**Re; Precinct B - Sites 2A & 3A,
Walker Street, Rhodes
Environmental Wind Assessment**

This report presents the results of a review of the Architectural Documentation as it has progressed towards a DA submission.

Drawing Name:
LANDSCAPE PLAN

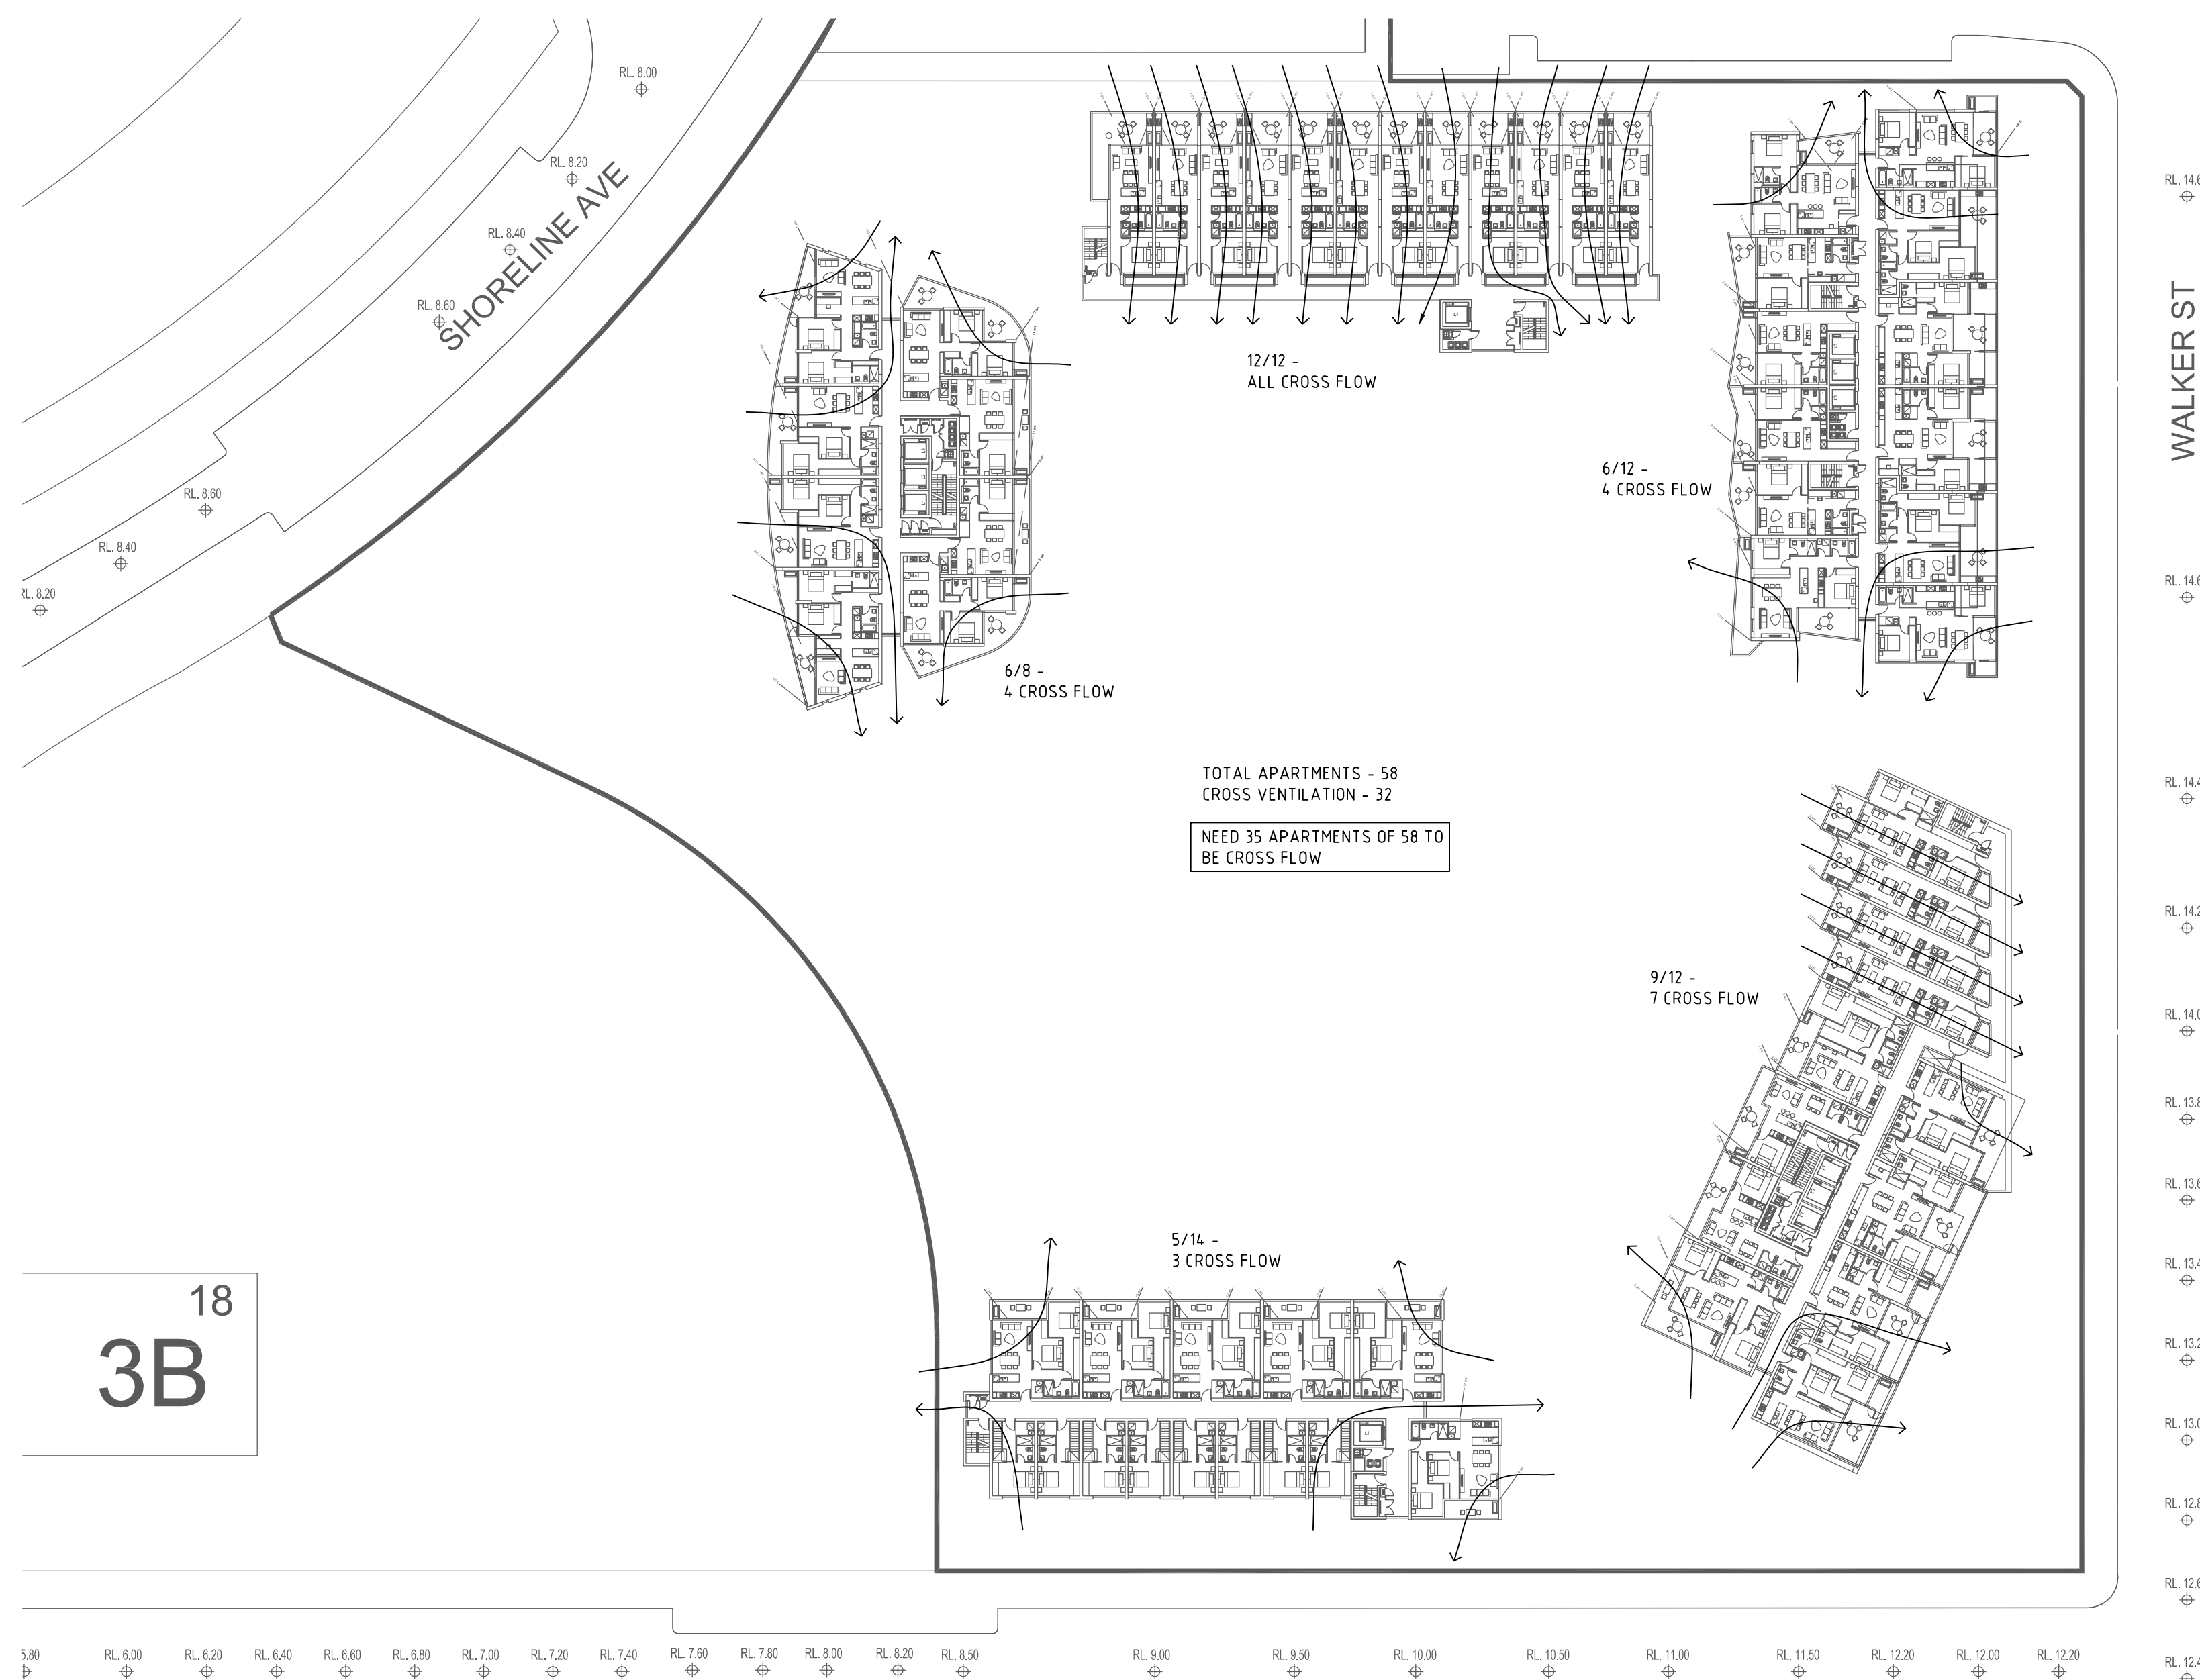
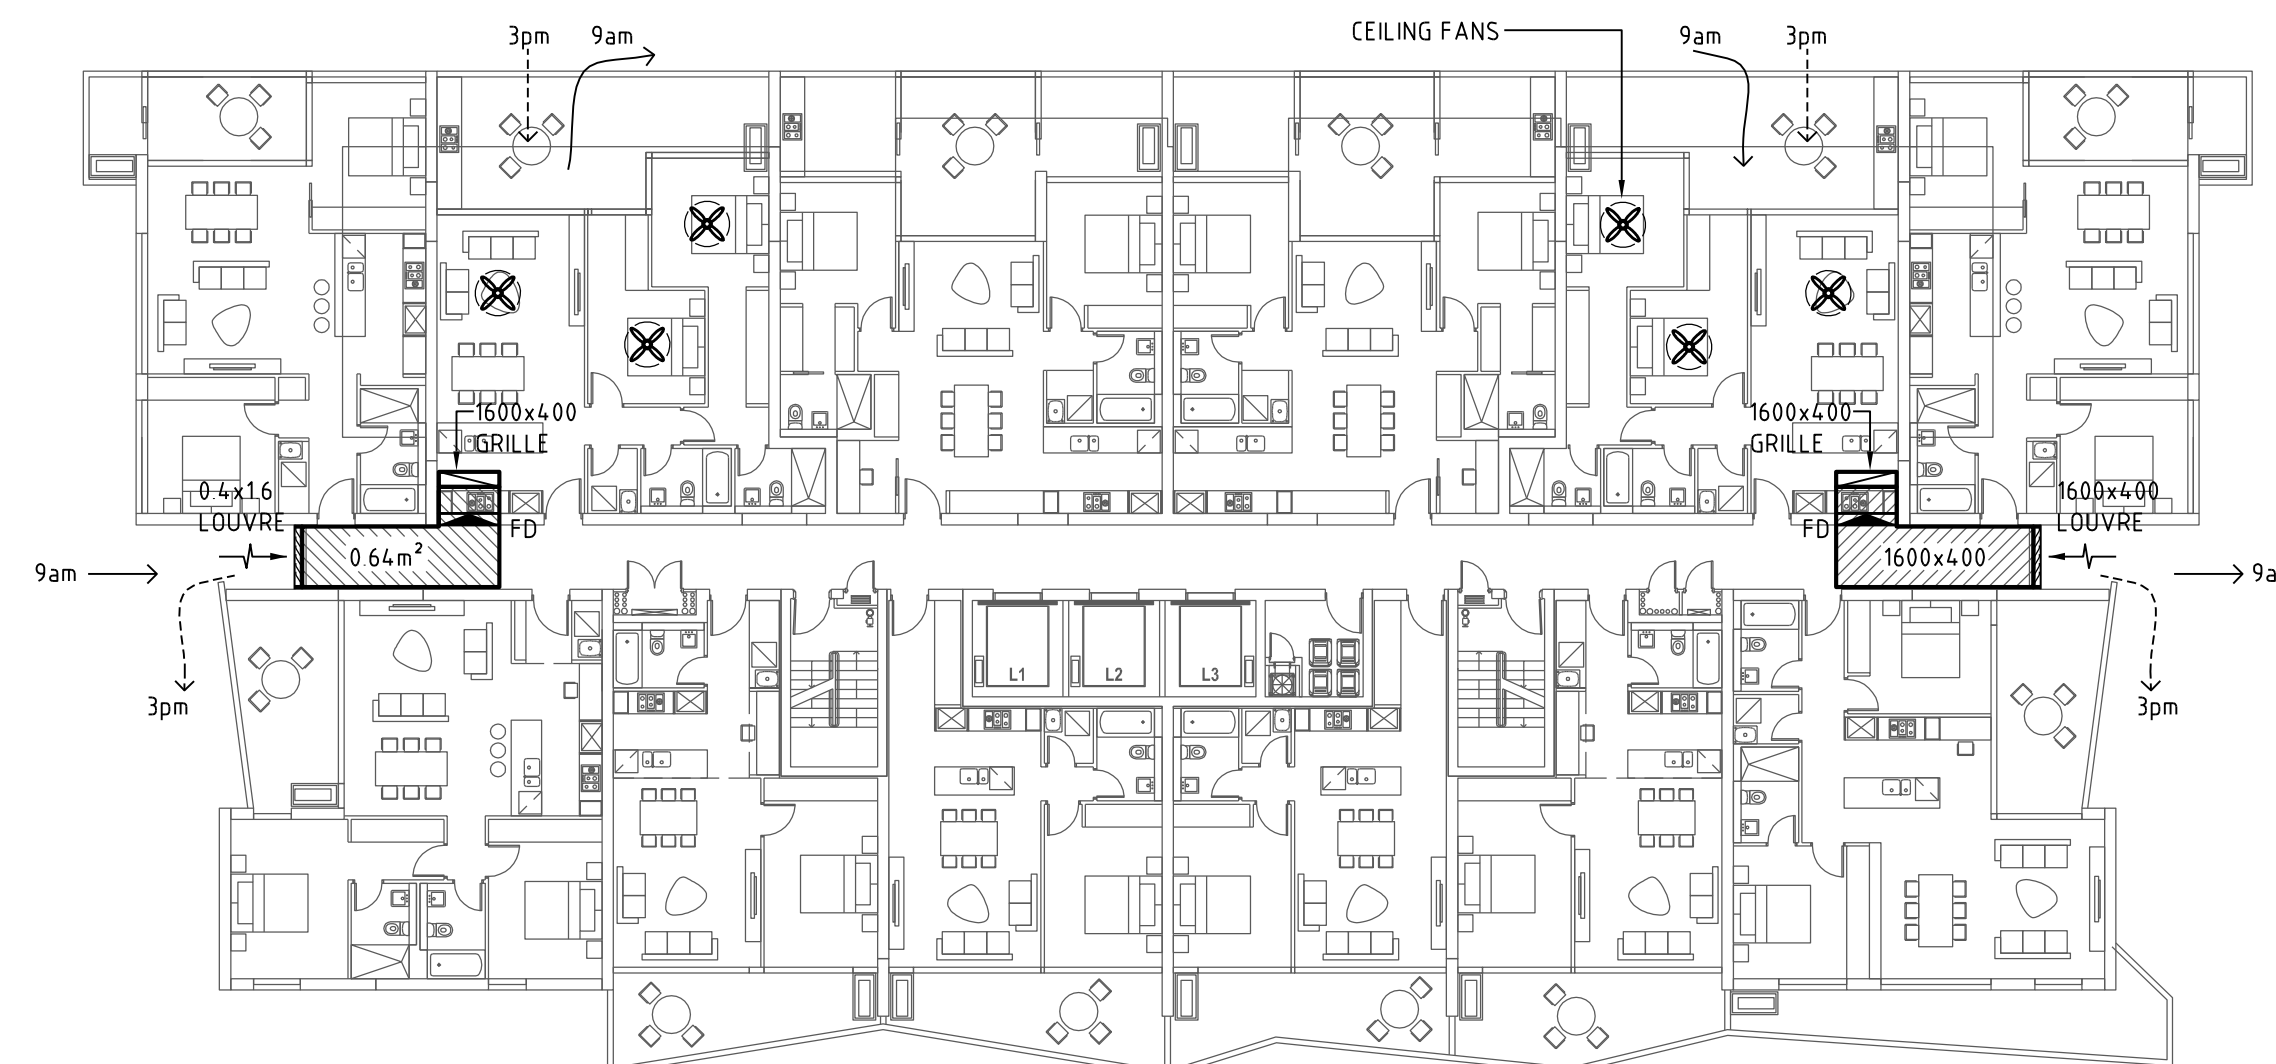
On the south side a wind-break feature has been incorporated between buildings A and D along with substantial landscaping so as to prevent wind conditions at this level exceeding the criterion for walking comfort for both westerly and easterly winds. Extension of the podium level canopies will also assist in controlling downdraft wind conditions at this point. The attached drawing indicates this.

To ensure that wind conditions meet the criterion for comfort for walking around this building we have introduced landscaping and screen wind-break features at the corners to keep pedestrian walkways away from the corners and to lift these corner flows so that they do not impact on the pedestrian entry points.

The step up in level from Shoreline Avenue creates the ability to make provision for wind-break screening or landscaping at the north-west and south-west corners which also creates a no-go zone for pedestrian traffic. The attached drawing indicates this.

To ensure that wind conditions meet the criterion for comfort for walking around these buildings we have introduced significant landscaping at the corners to keep pedestrian walkways away from the corners and to lift these corner flows so that they do not impact on the building entry points.

LEGEND
 ADDITIONAL CANOPIES TO BUILDINGS A AND D TO COUNTER DOWN DRAUGHTS

ADDITIONAL TREES AND SHRUBS TO COUNTER THROUGH DRAUGHTS
